Markup Summary

dsdparsons (4)

PAINT BRUSH HILLS FILING 14  
CONCEPT PLAN

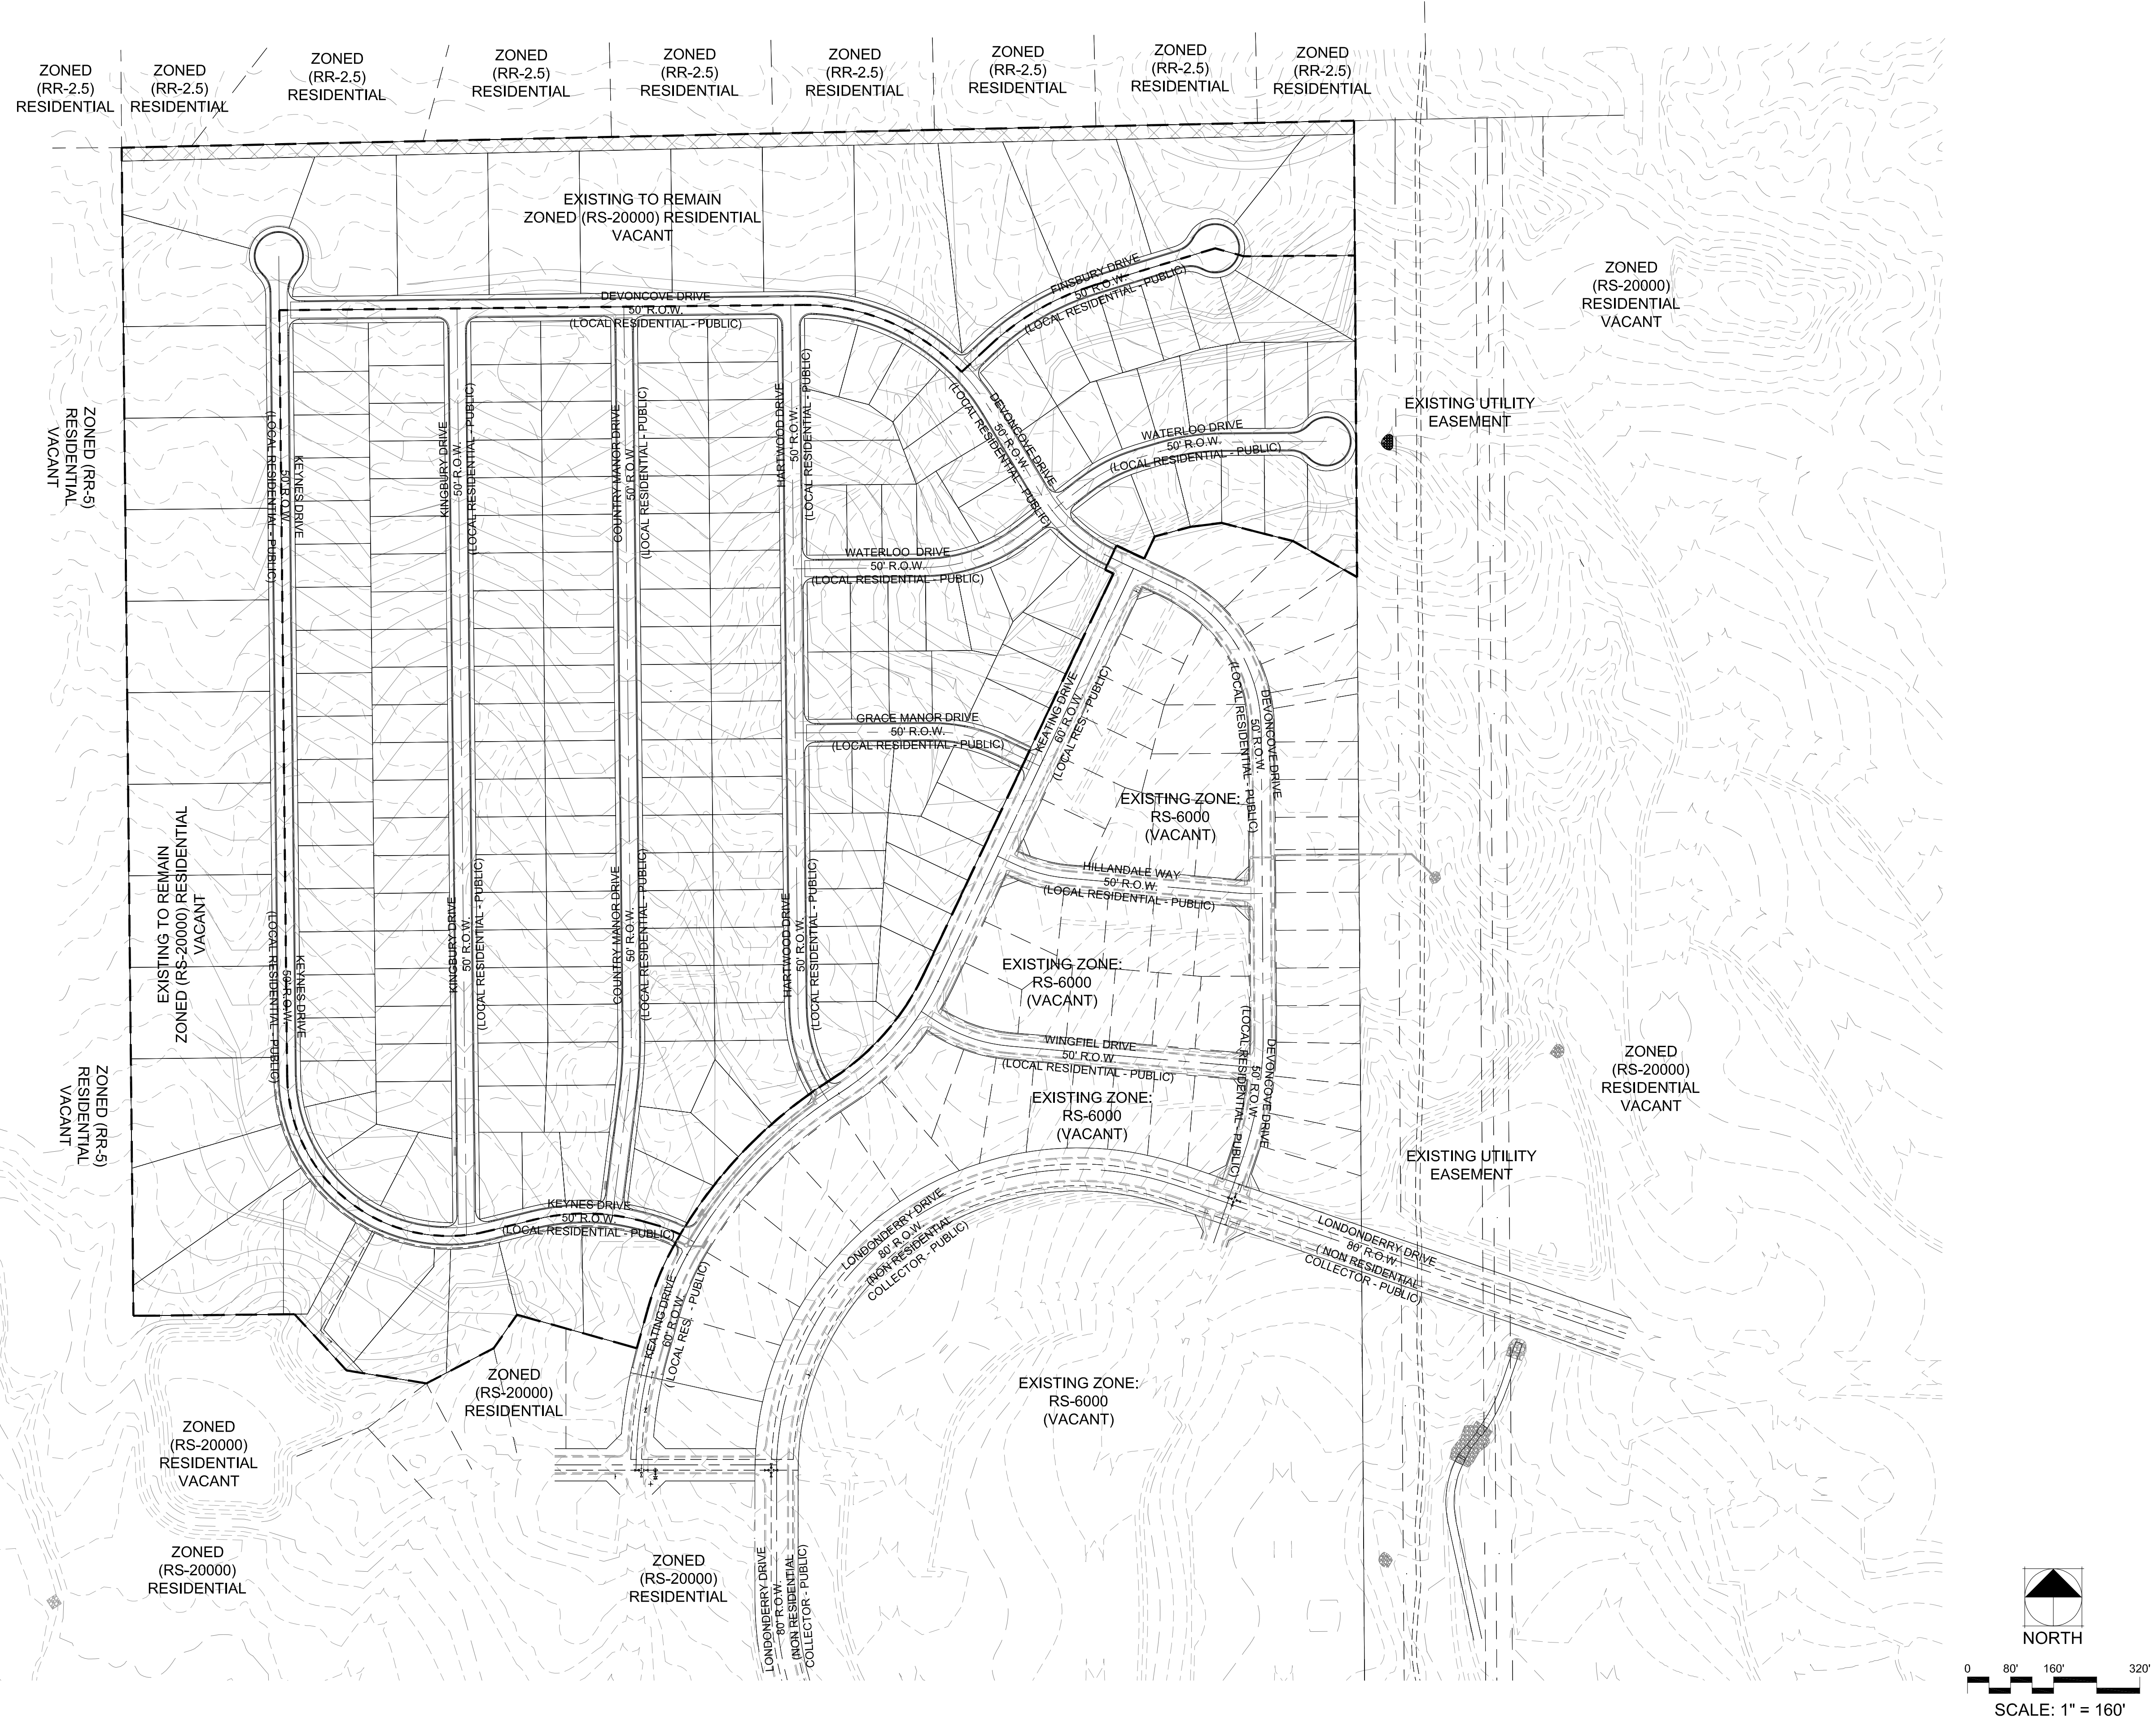
Add ownership of adjacent properties and existing structures within 500'

You may want to add a label that this is part of the existing Paint Brush Hills

There is platted ROW, and stub out to be shown here.

and 15?
